PRELIMINARY SHORT PLAT APPROVAL

PROJECT INFORMATION										
Project Title	Linscott-Kirk Short Plat			Date of Report	March 5, 2024					
File Number	SP23-006			Attachments	Preliminary Short Plat Map (Exhibit 19 – see attached)					
Administrative Recommendation	Approve the preliminary 3-lot short plat subject to the recommended conditions of approval.									
BACKGROUND SUMMARY										
Applicant	Robert Linscott									
Request	The applicant is proposing a 3-lot short plat. Lot 1 and 3 are proposed as duplex lots with Lot 2 proposed as one single family residence, for a total of (5) units. The proposed lots would be accessed via a private access tract off of 48 th Drive NE.									
Site Address	9803 48 th Drive NE			APN(s)	00538500001200					
Legal Description (abbreviated)	Lot 12 of Palmer Tracts			Section	16	Township	30	Range	05E	
Comprehensive Plan	Single Family High	Zoning	R-6.5	Shoreline Environment			N/A			
Water Supply	Current	Proposed		Sewer Supply	Current		Proposed

PRELIMINARY SHORT PLAT MAP  
 FOR  
**LINSCOTT - KIRK SP**  
 IN THE SE 1/4 OF THE SE 1/4 OF SECTION 16, TWP.30 N., R.5 E., W.M.  
 CITY OF MARYSVILLE, SNOHOMISH COUNTY, WASHINGTON

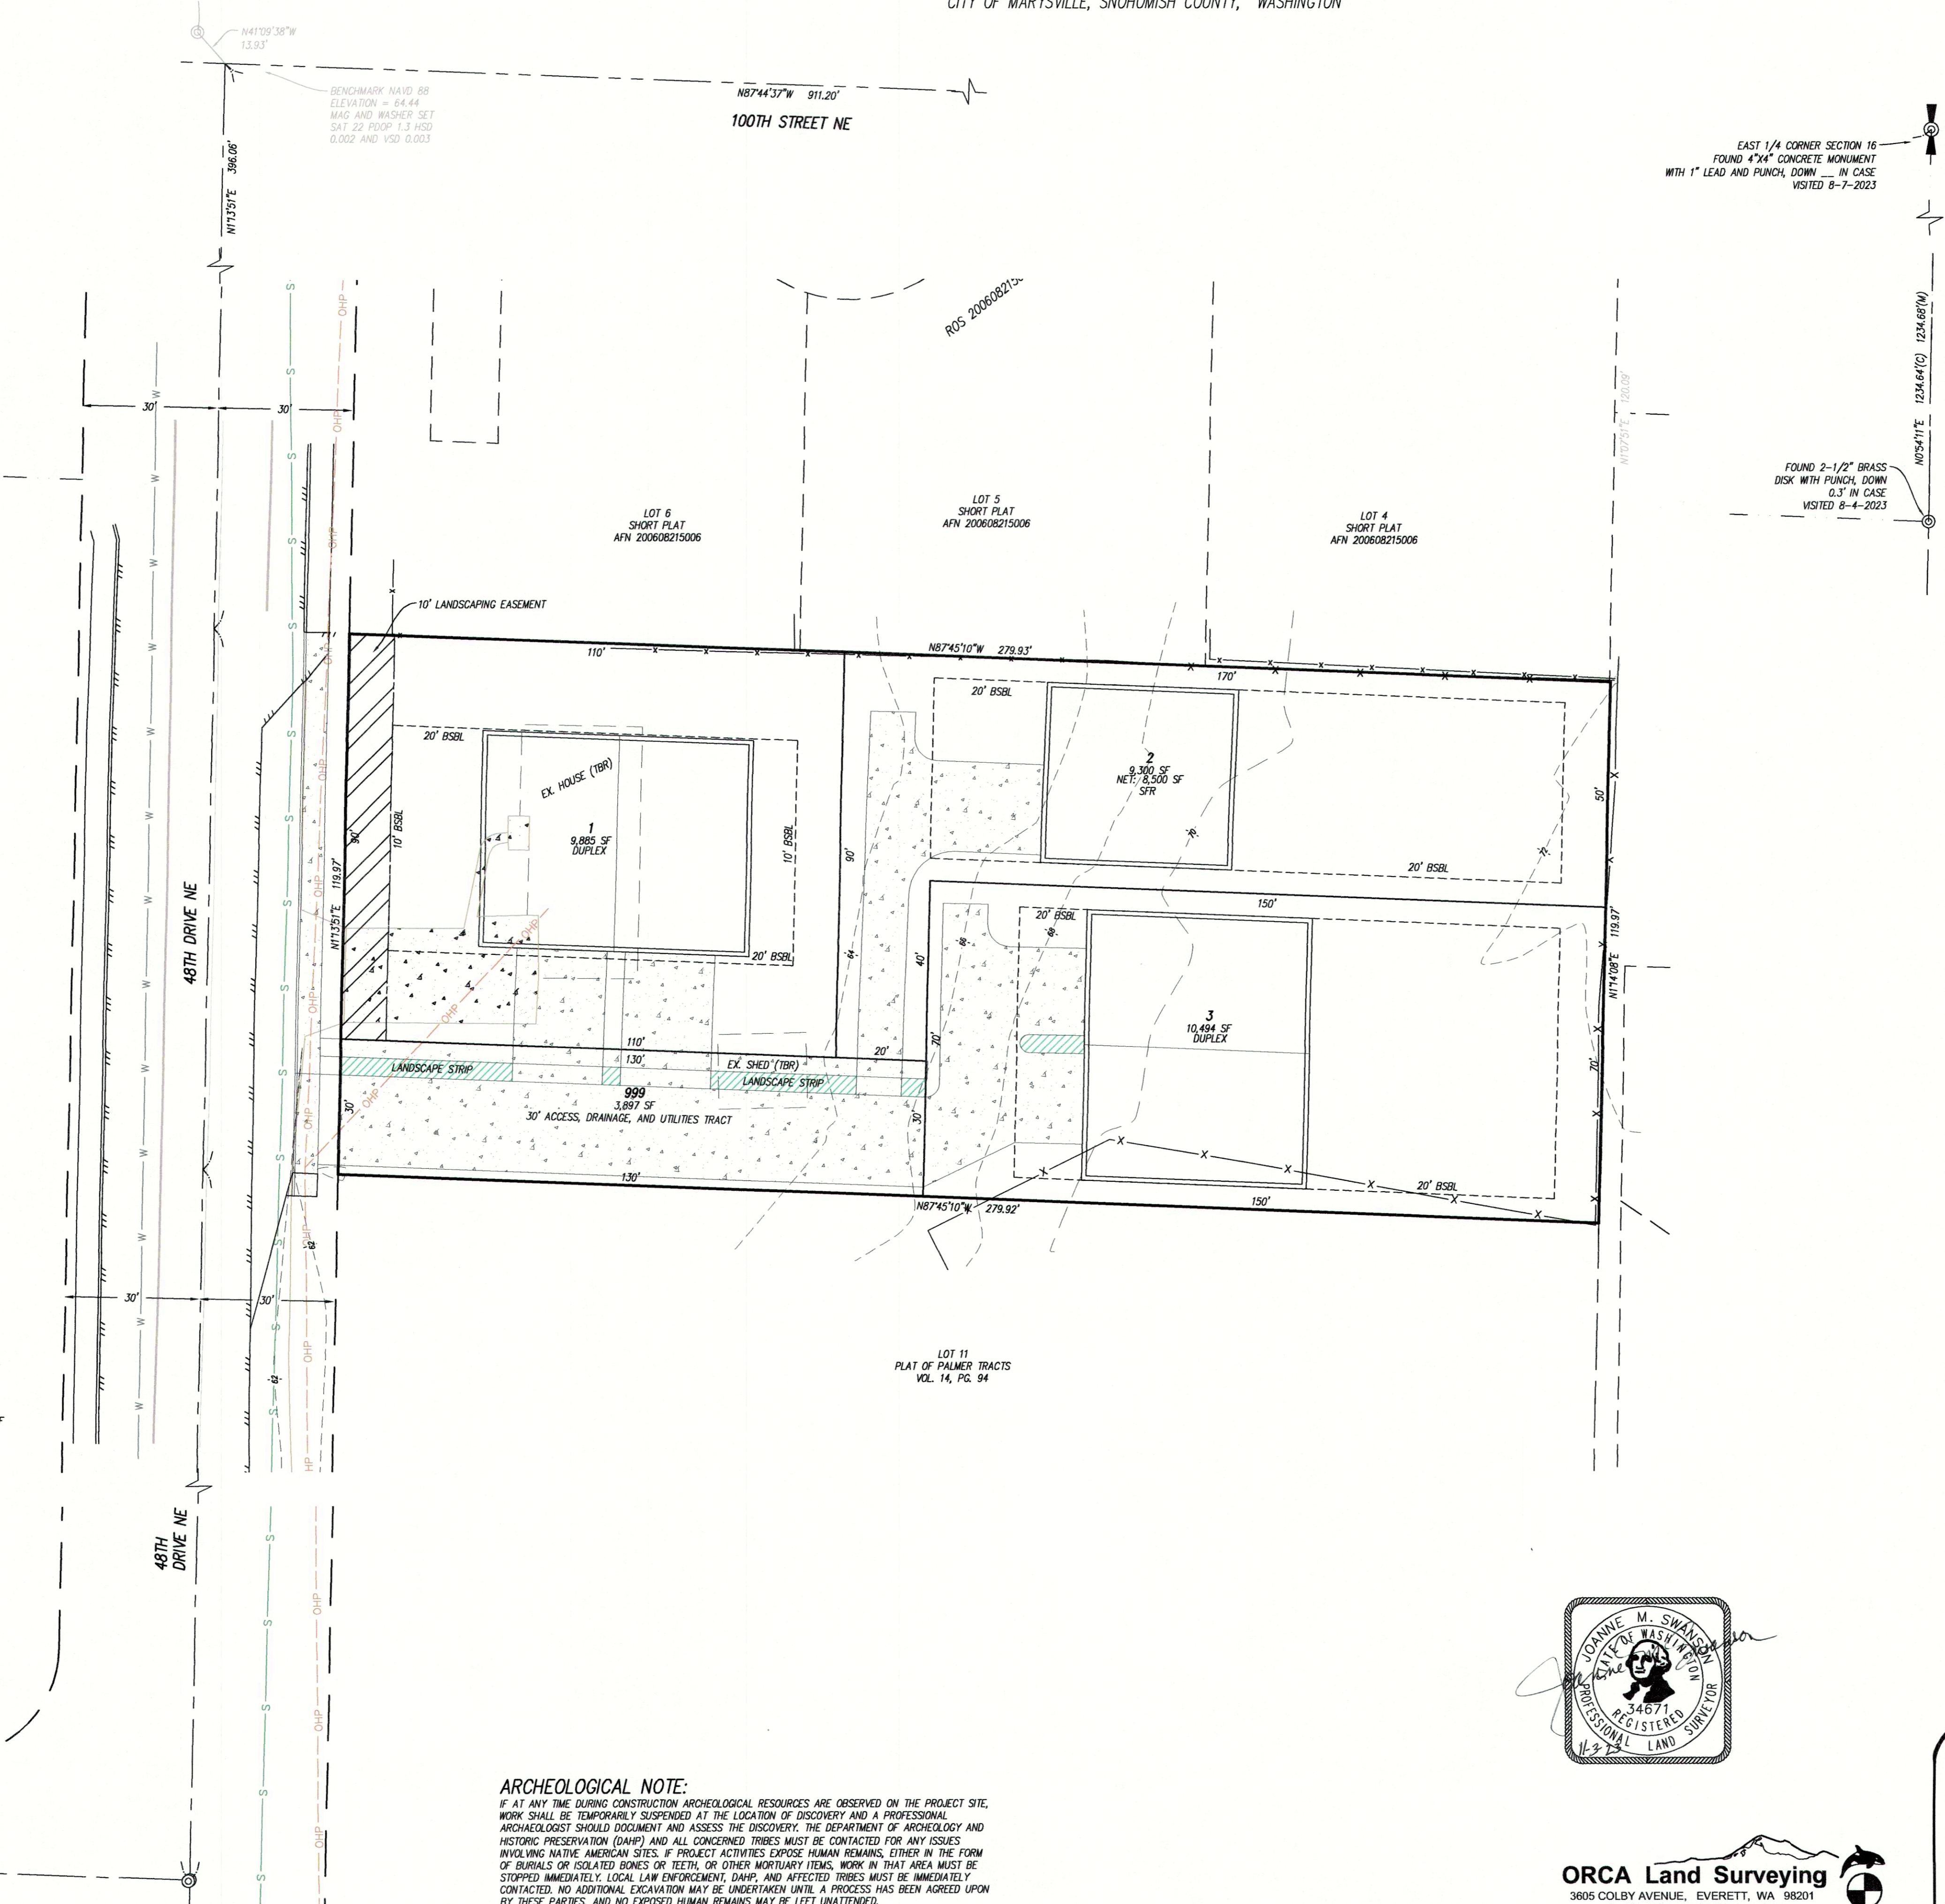
1. The preliminary short plat map (Exhibit 19) shall be the approved site layout.
 - 1.1. Pursuant to MMC 22C.010.290(2), sites shall be oriented to create an attractive street edge and are to have primary entrances facing the street. The proposed duplex unit closest to 48th Drive NE (Lot 1), shall be oriented with a façade facing 48th Drive NE and provide a pedestrian pathway connecting to the sidewalk.
2. Prior to civil construction plan approval, a final landscaping plan meeting the requirements outlined in MMC Chapter 22C.120, *Landscaping and Screening*, shall be submitted for review and approval. All required landscaping, fencing, and open space improvements shall be installed prior to final PRD approval.
